SSD 7462

**Bingo Resource Recovery Facility, 13 Pembury Road, Minto (SSD 7462)
Request for Response to Submissions**

ATTACHMENT 1 – DEPARTMENT OF PLANNING AND ENVIRONMENT ISSUES

Figure 4 Proposed Flow Diagram – Waste and Vehicle Movements

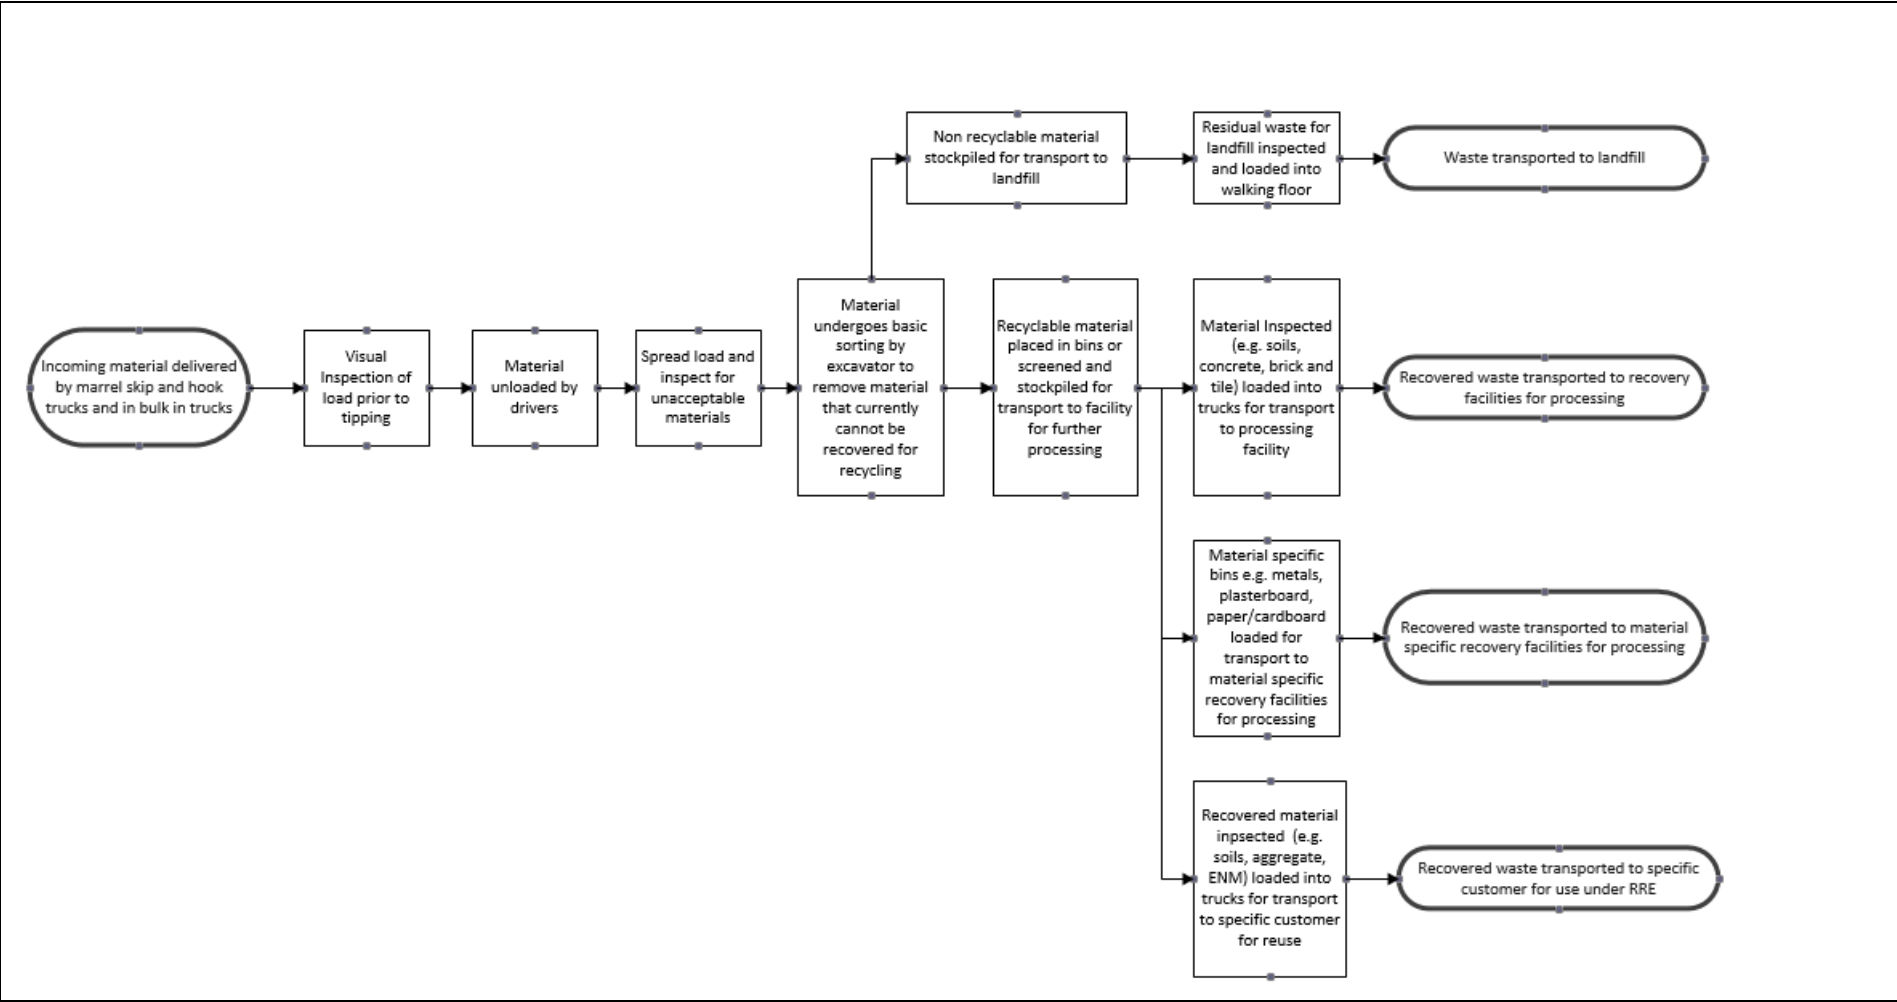
- a. location of trucks used for loading; and
 - b. frequency and method of loading.
6. The flow diagram in Figure 8 of the EIS indicates that a conveyor will be used to transfer brick and concrete, as well as soil from Shed B to Shed A. However, section 4.2.3 of the EIS states that only soil will be transferred to Shed A using the enclosed conveyor. Revise Figure 8 and clarify how each waste stream will be transferred from Shed B to Shed A and the timing of these transfers.

PROJECT No. 15016	SCALE N.T.S	REV. A
-----------------------------	-----------------------	------------------

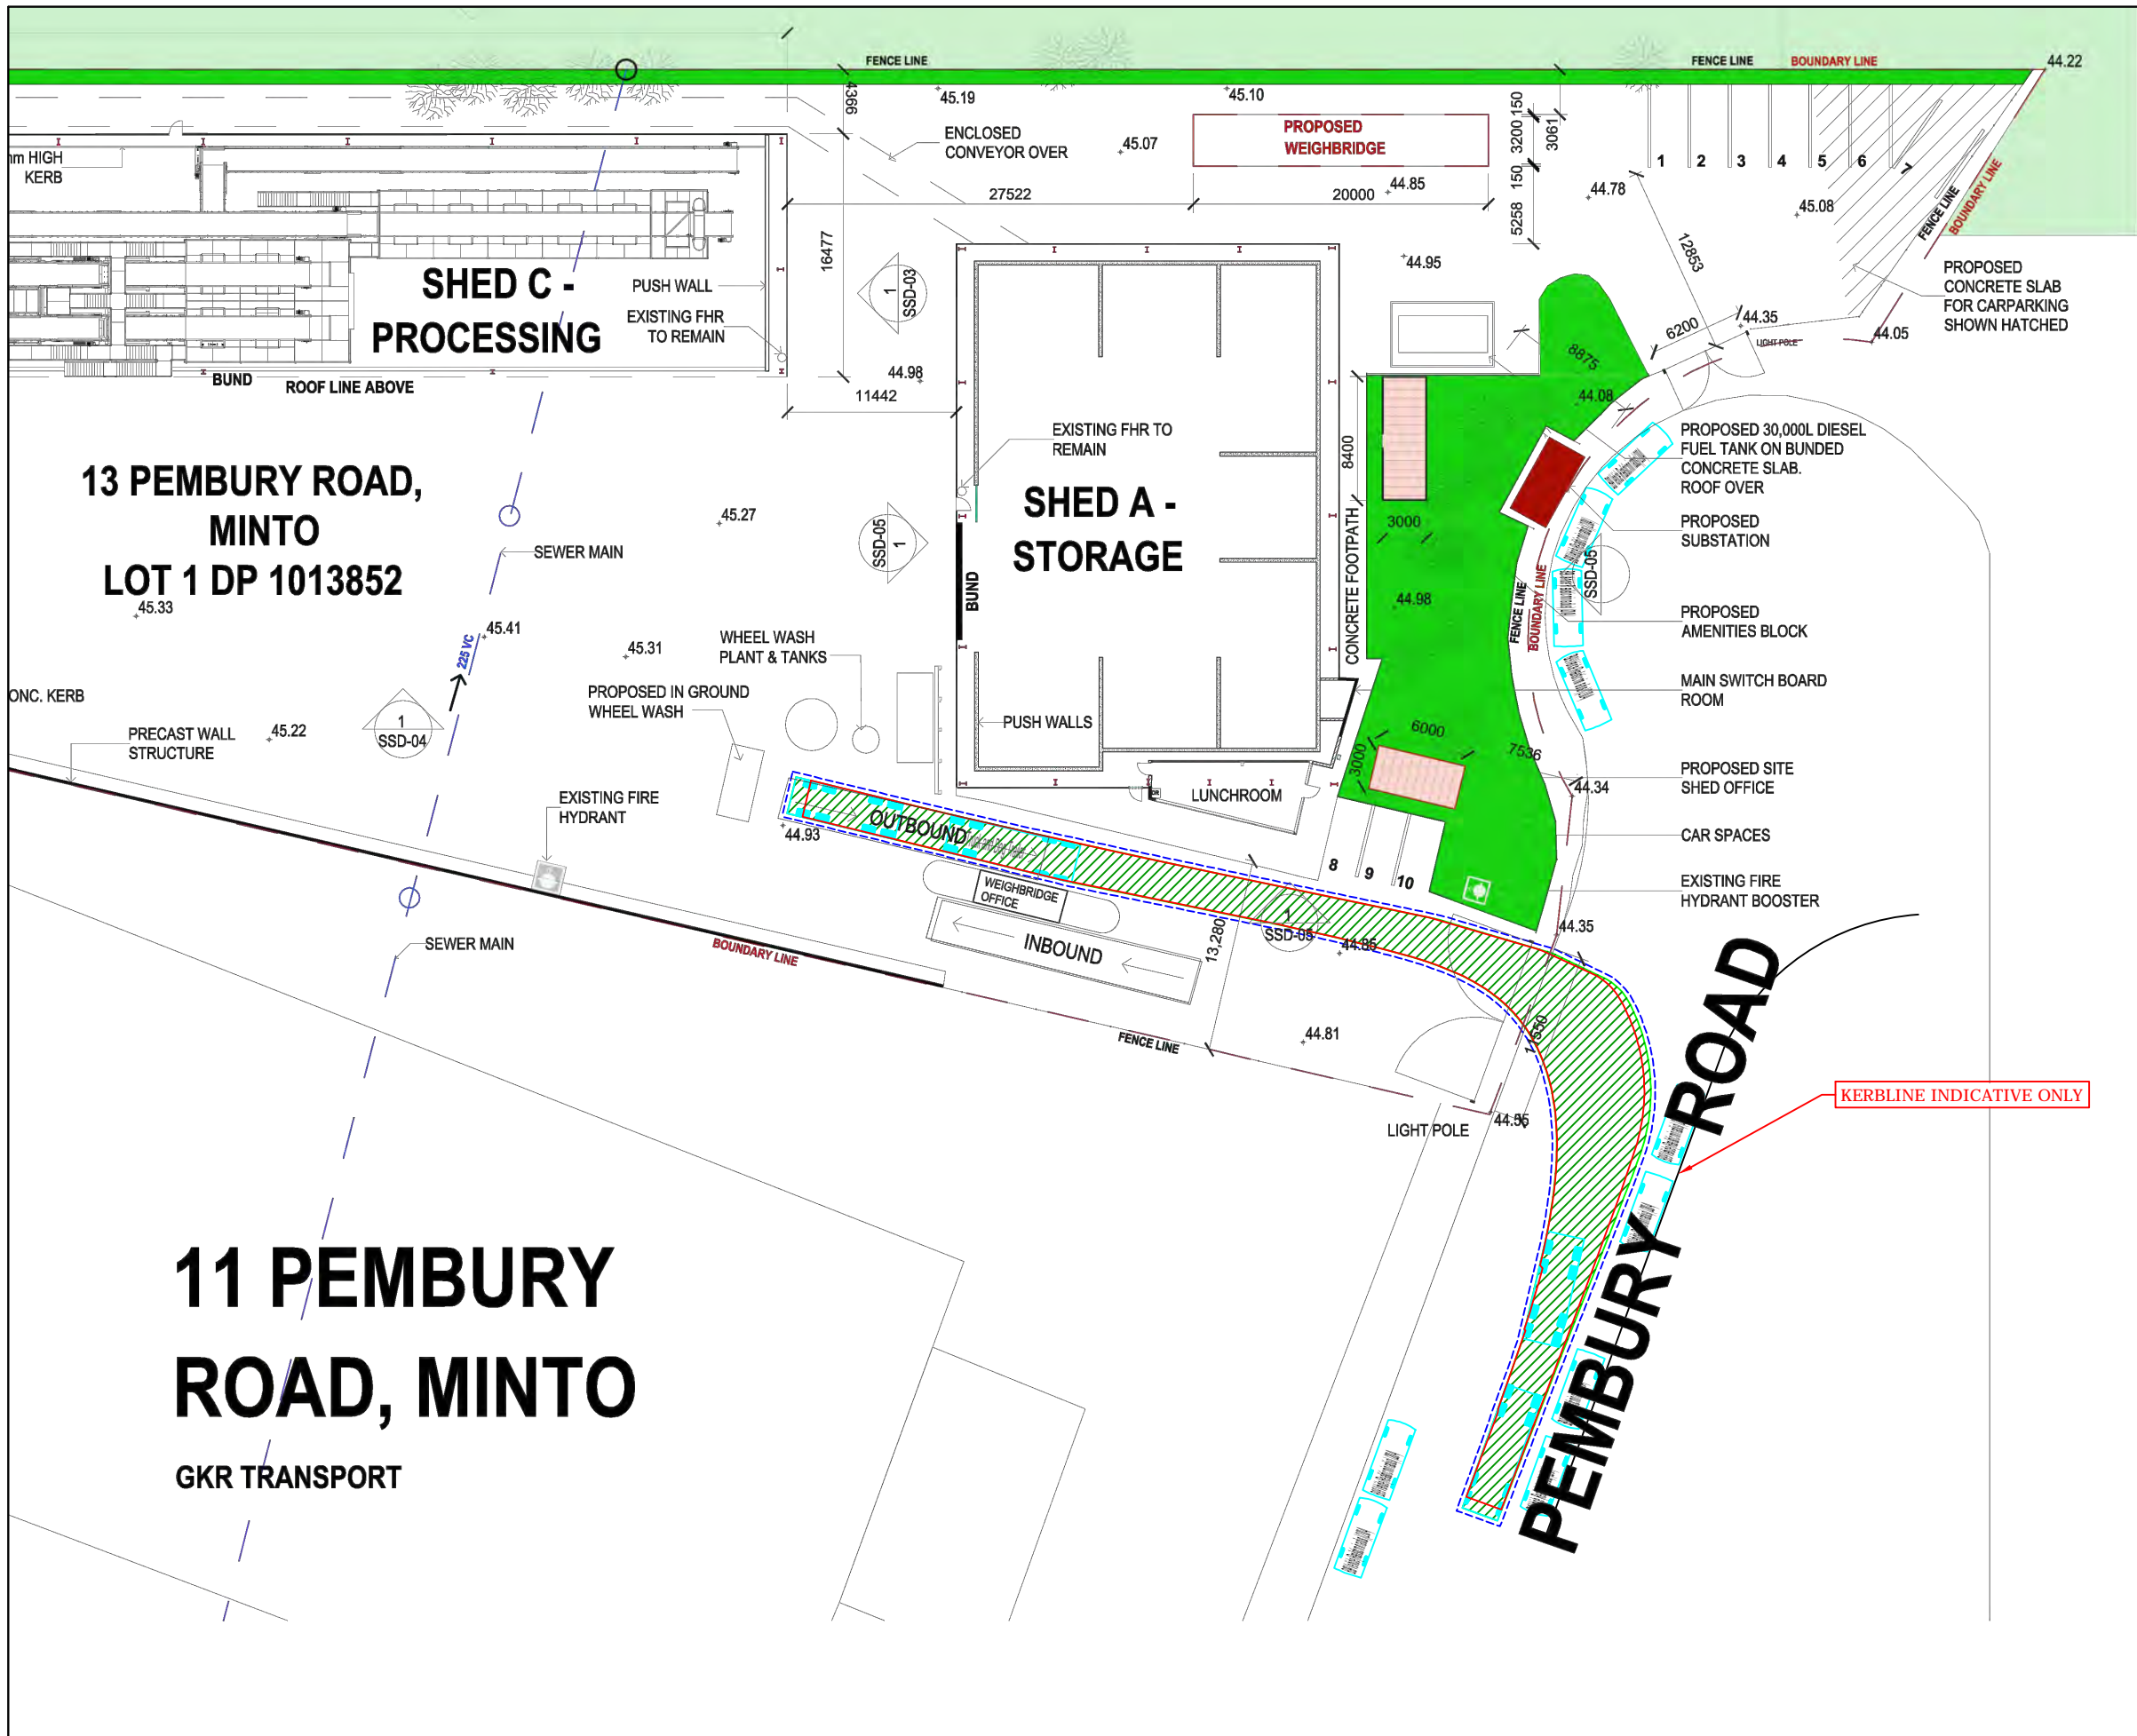
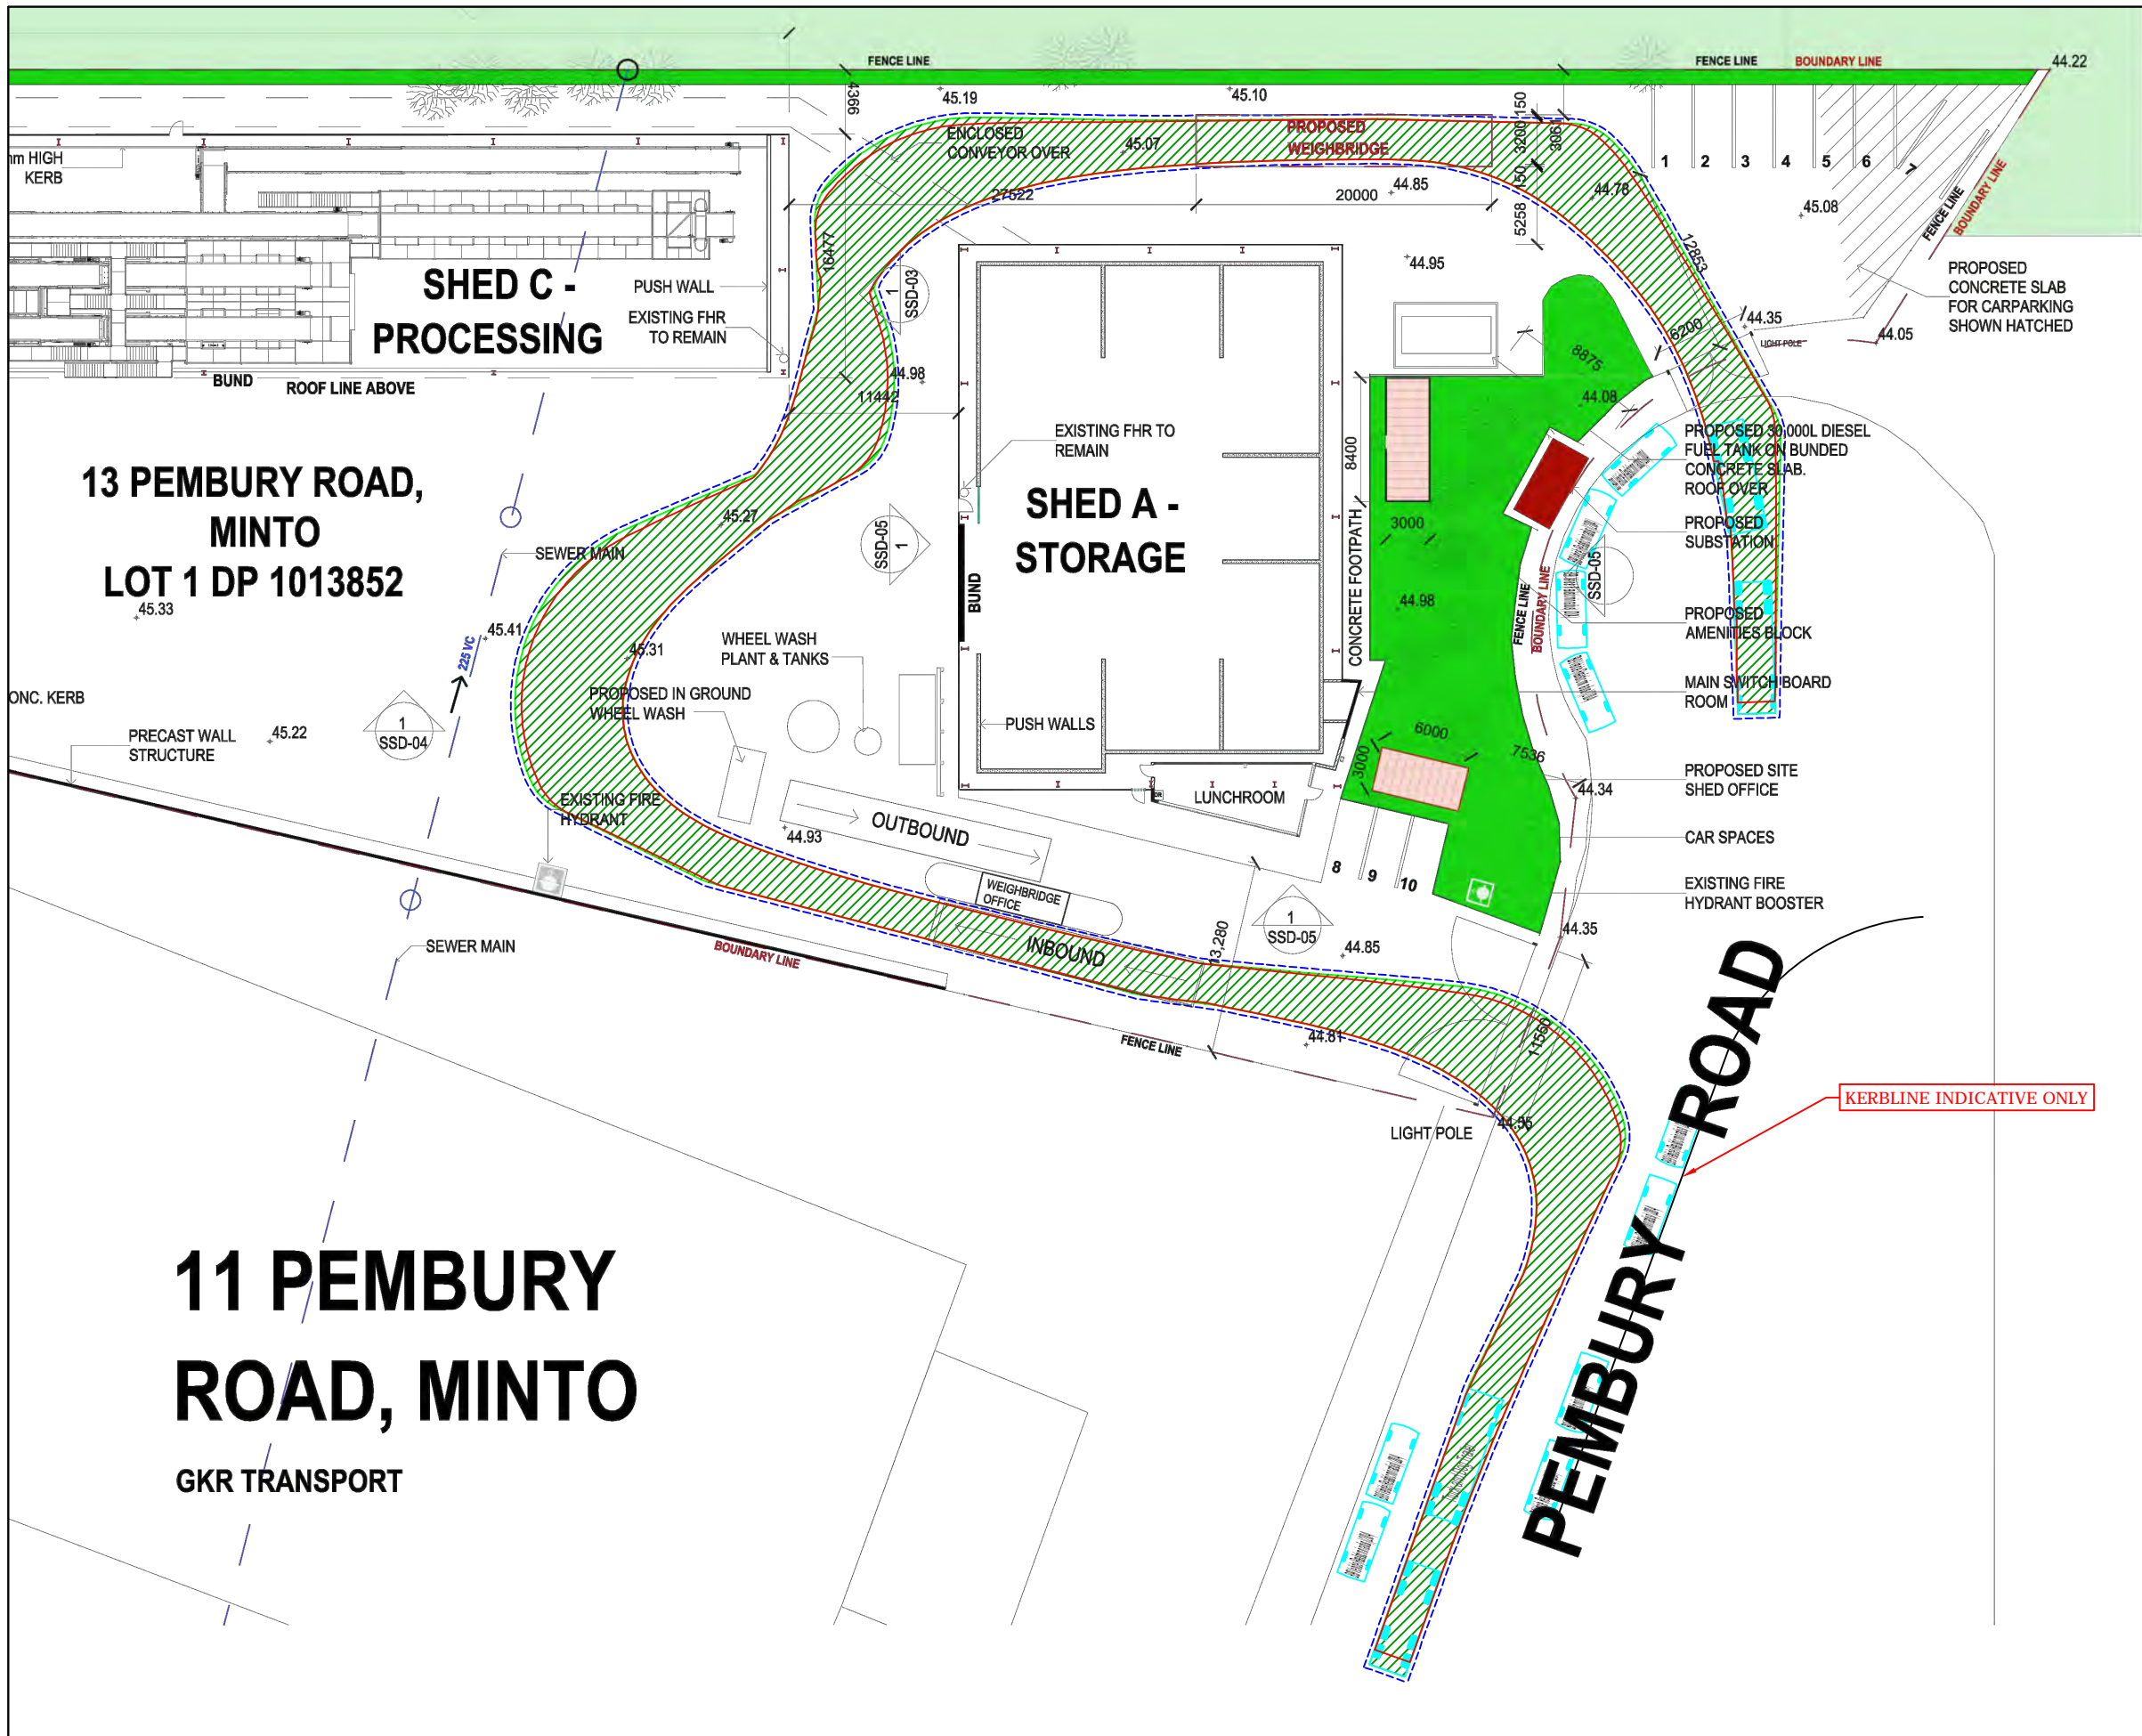
25. Demonstrate how conflicts with the largest vehicles entering the site and vehicles exiting the site will be managed.
26. The Transport Impact Assessment states that two (2) spaces for articulated trucks (19 metre (m) trucks) are available for stacking. However, the Swept Path for articulated trucks shows that only one 19 m truck could be stacked. Please provide clarification.
